Recommendation Report for Lawful Development Certificate for a Proposed Use or Development

REF NO: FP/181/21/CLP

LOCATION: 1 Sunnyside Cottages
Flax Mean
Felpham
PO22 8RB

PROPOSAL: Lawful development for a proposed loft conversion and flat roof dormer to the rear elevation of the property.

DRWG No: BSB/21/890/2/A

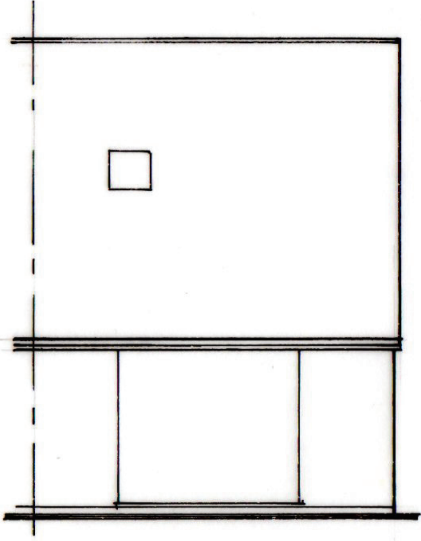
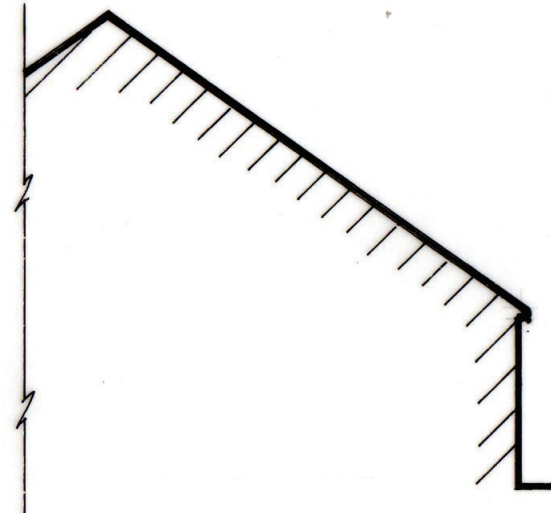
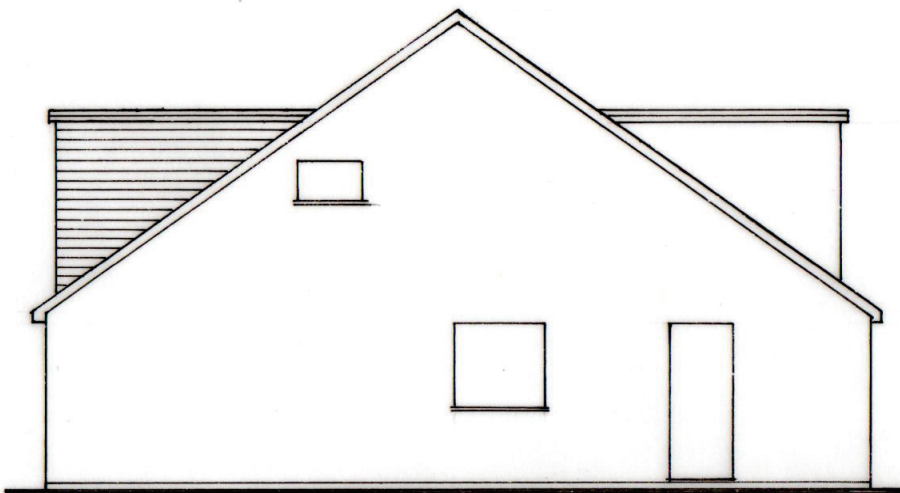
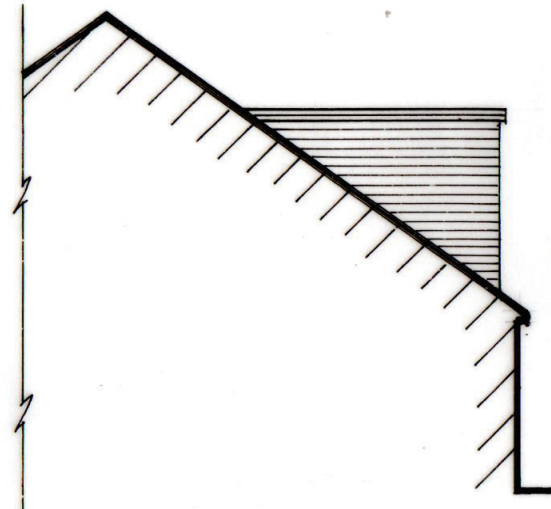
Examination of the site history has revealed a condition on the original permission under FP/114/87 which states' No windows other than those shown on the plans hereby approved shall be constructed at first floor level in the south, east and west elevations of the building without the prior permission of the Local Planning Authority on an application in that behalf.'

As such this restricts the installation of a dormer window under permitted development and consequently requires the submission of an application for full planning permission.

- A condition on the original permission FP/114/87 restricts the addition of a window to the southern elevation without prior consent from the LPA.
